Our Ref: FG/159/18/PL
Your Ref:

Town & Country Planning Act 1990 (as amended)
Town and Country Planning (Development Management Procedure) (England) Order 2015
Application for Planning Permission

Development Two-storey extension to the existing Cafe in order to provide increased internal seating, multi-purpose space, with improved service & food preparation area, disabled access & bike storage.

Location The Bluebird Cafe South Drive Ferring

02  
2002  
PROPOSED FIRST FLOOR PLAN  
Scale: 1:100

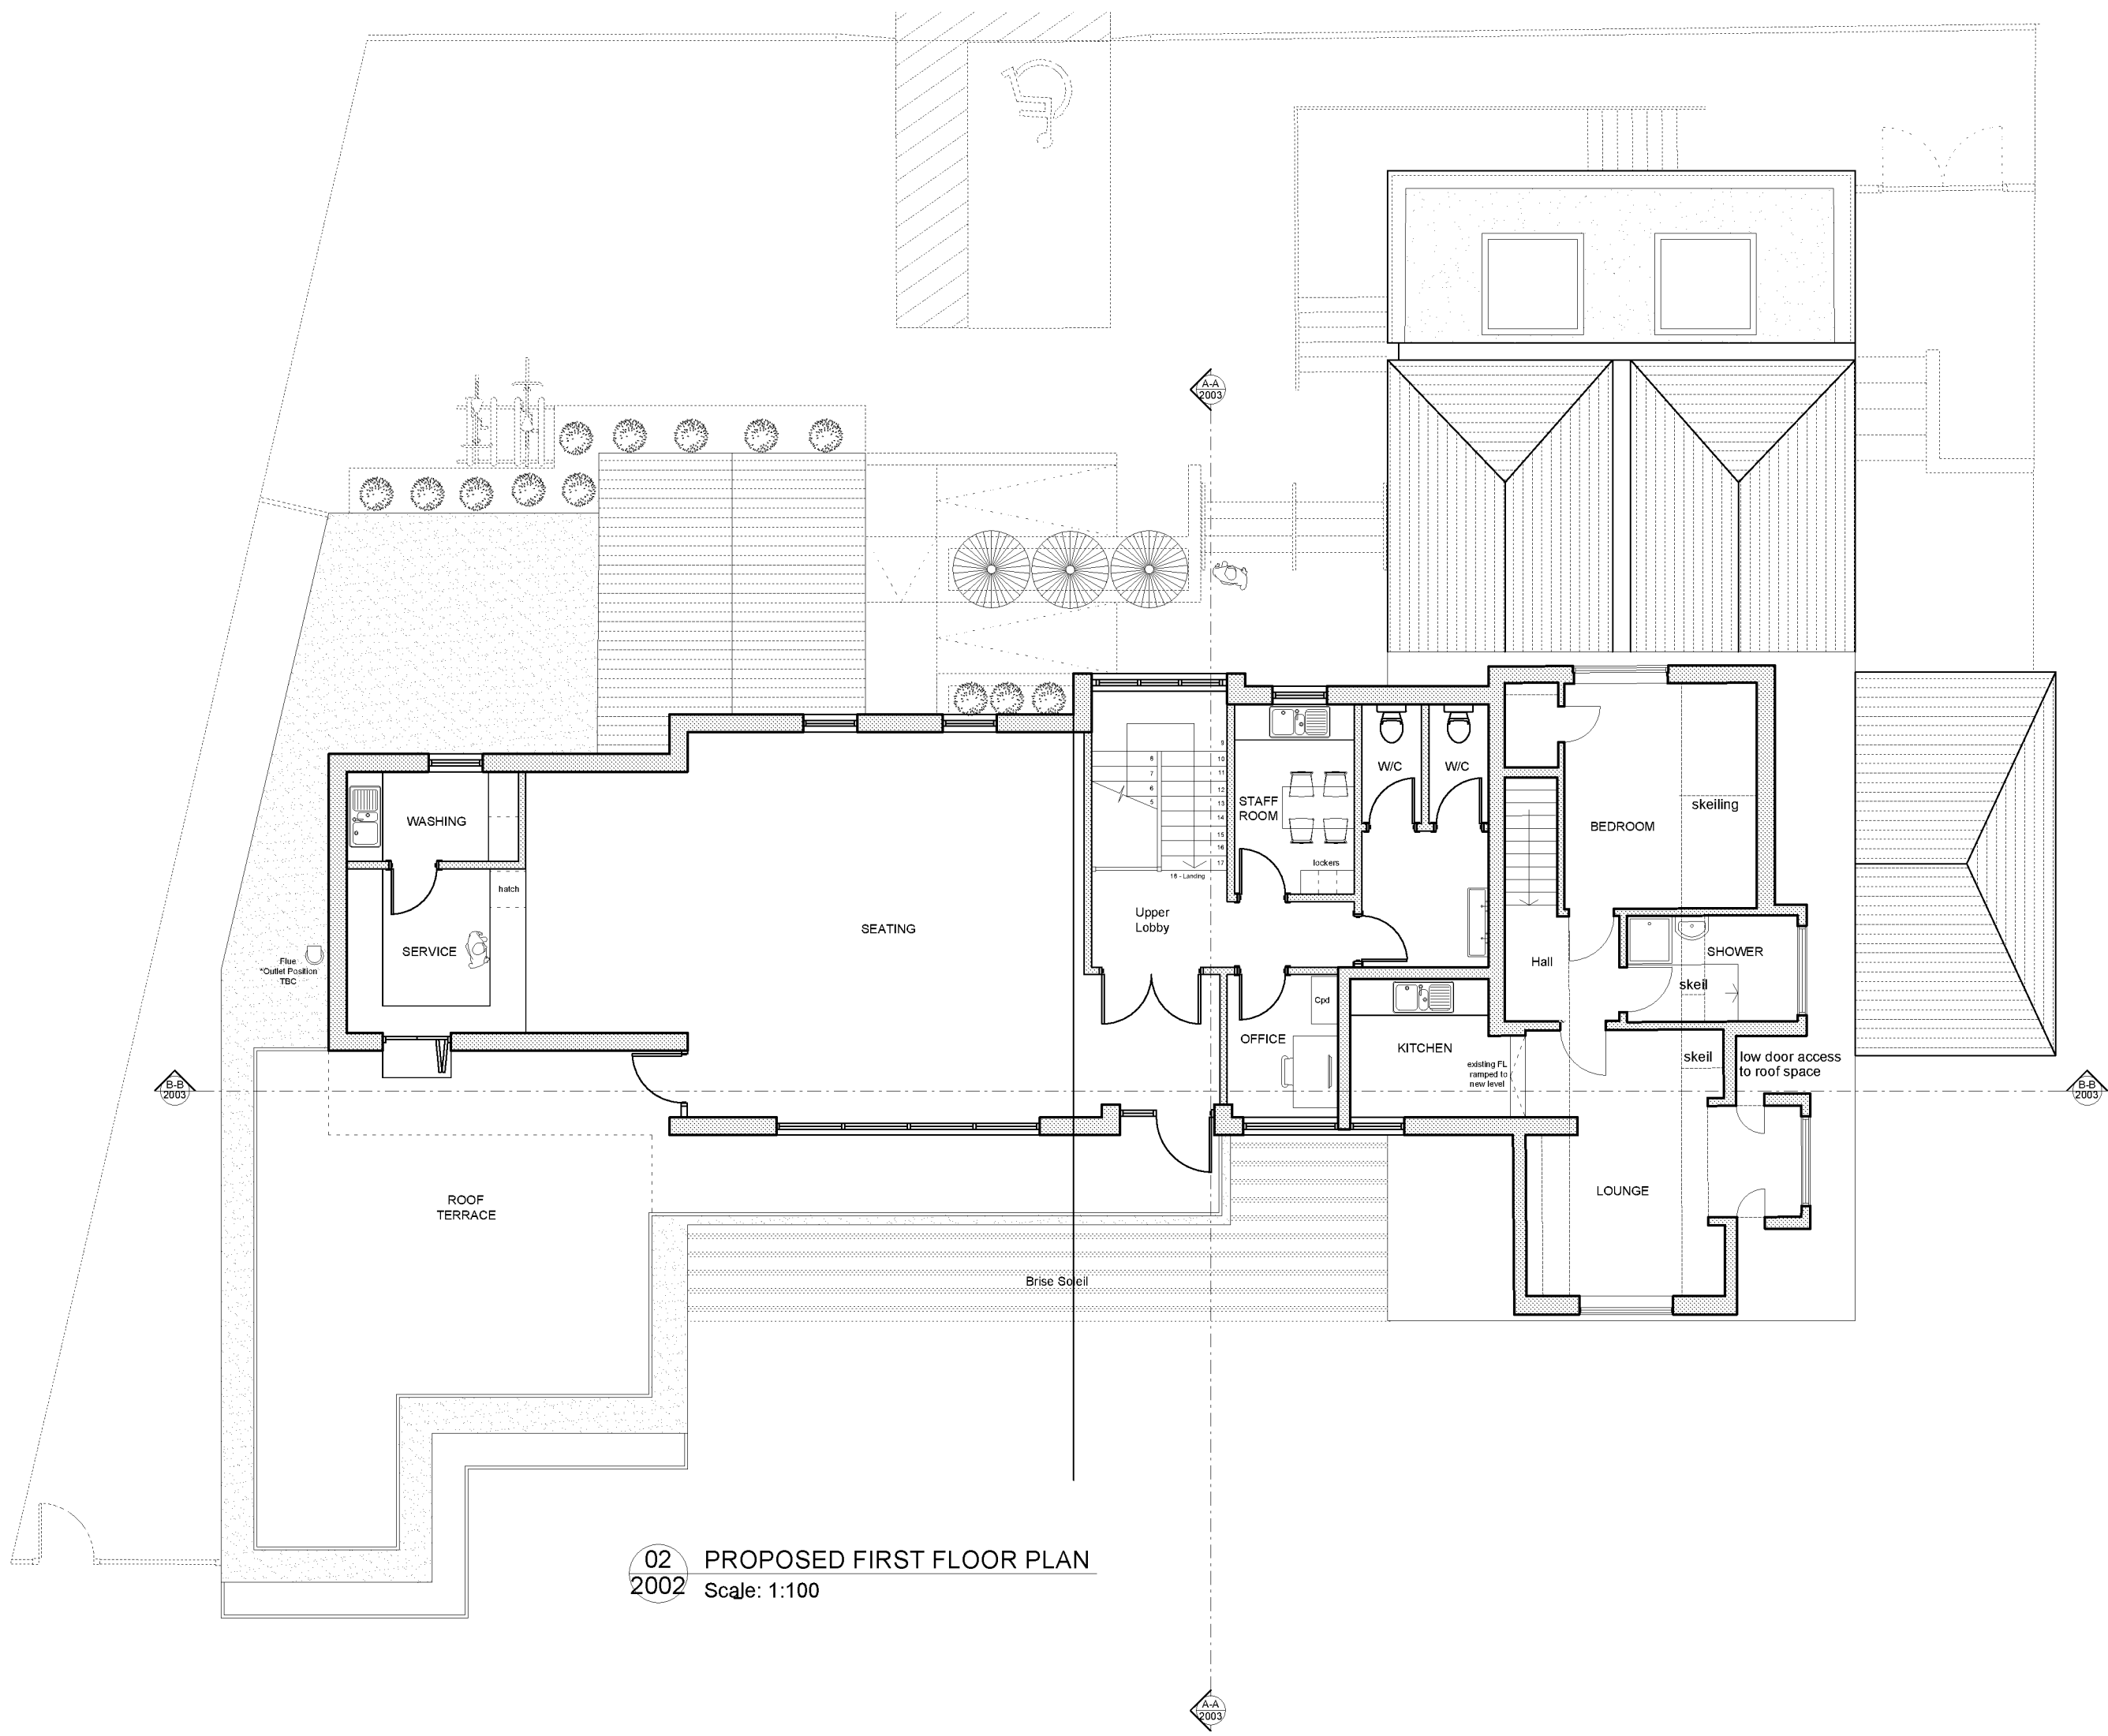
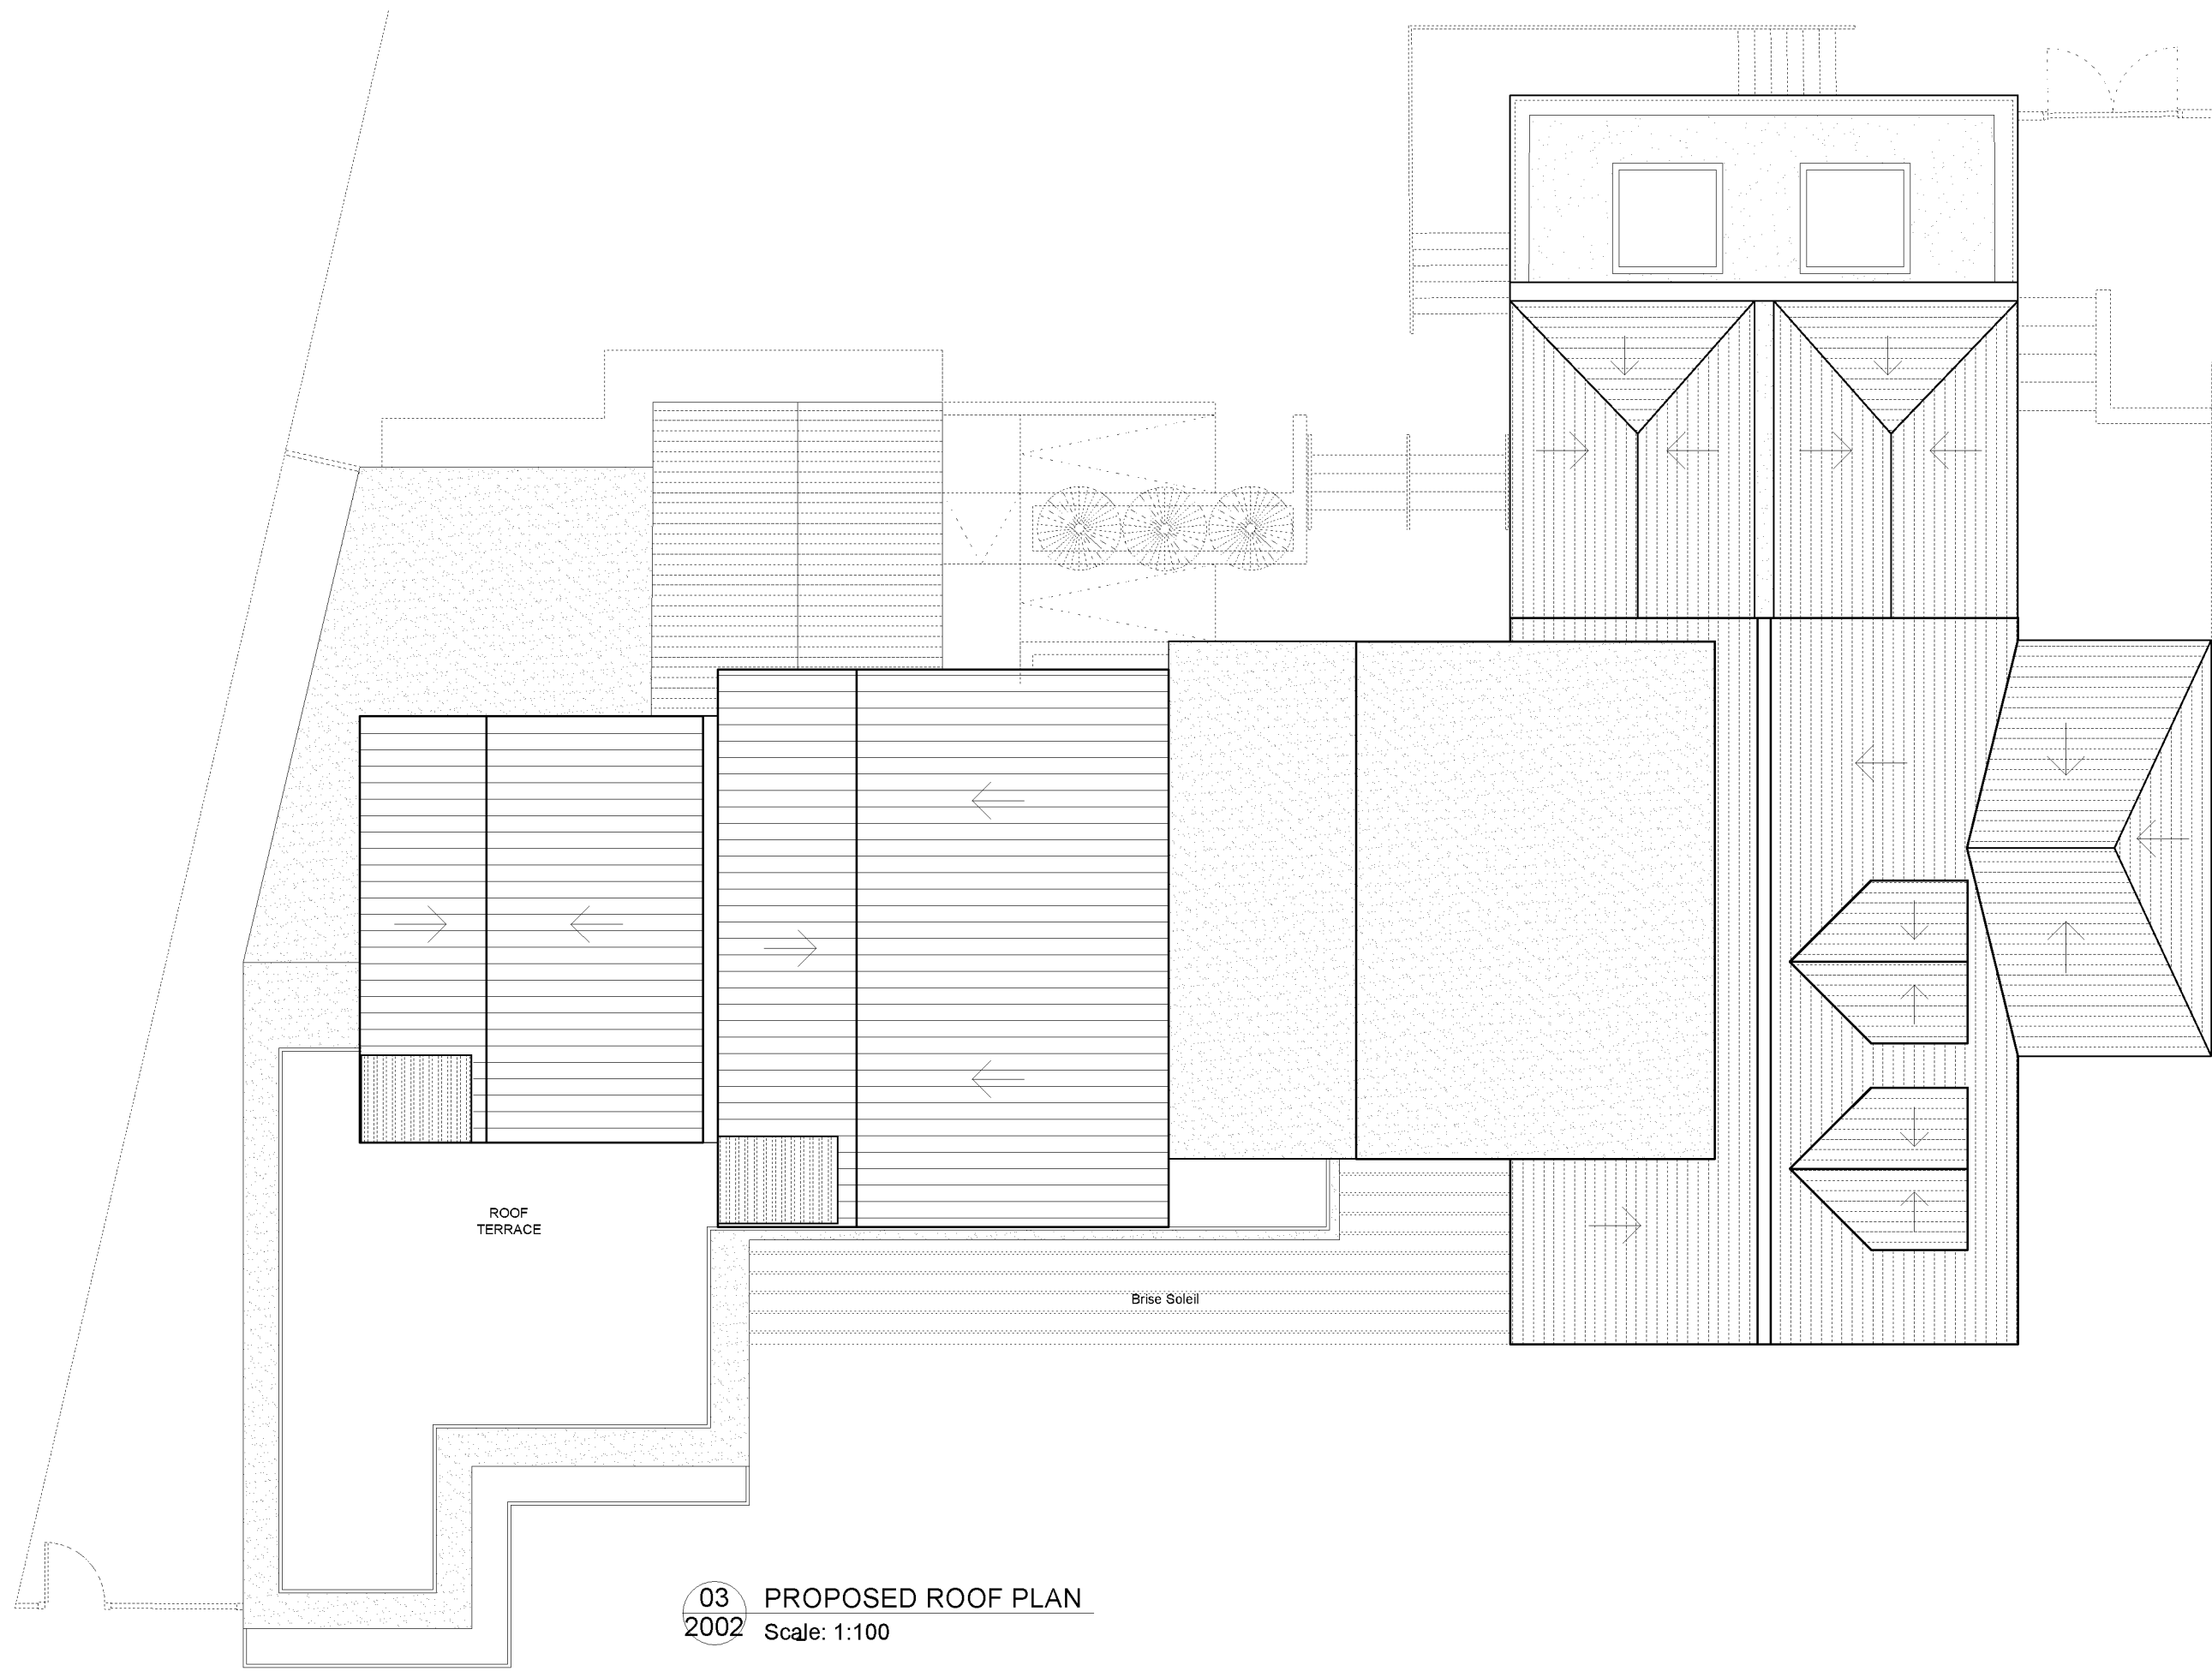
The door on the 1st floor leading to (leading to the roof terrace) does not scale correctly.

The entrance doors do not accord with the elevations.

Please forward amended plans.

03 PROPOSED EAST ELEVATION  
2003 Scale: 1:100

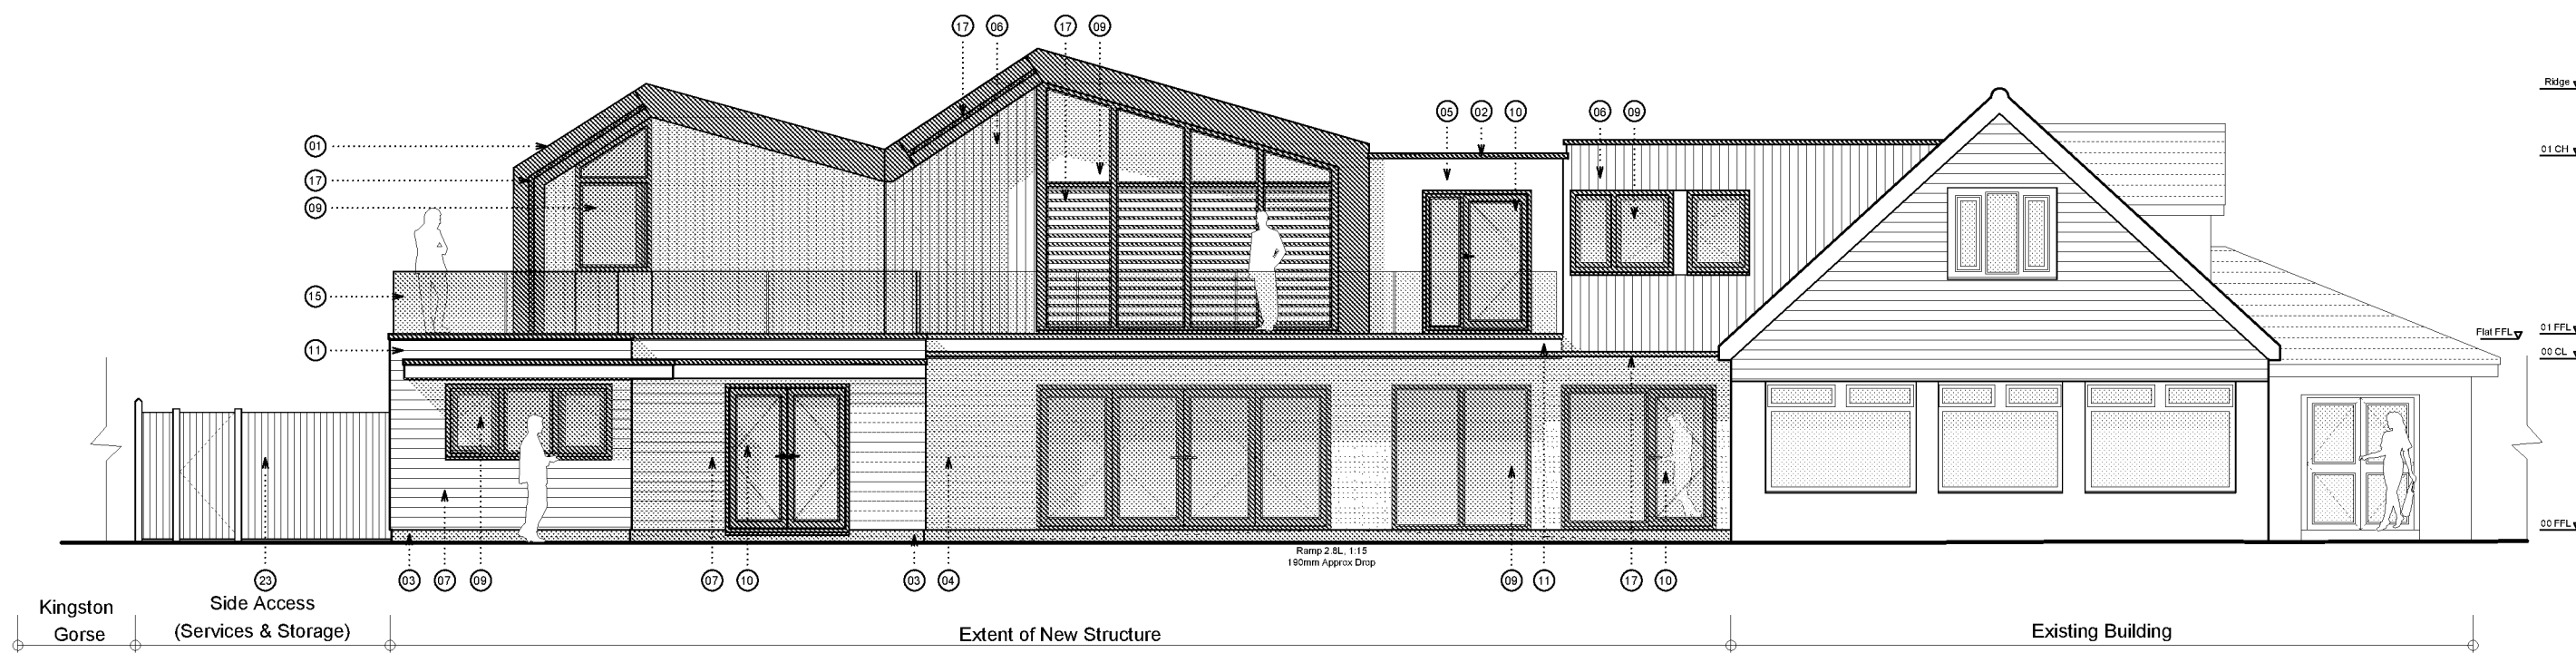
A window is missing from the east elevation.
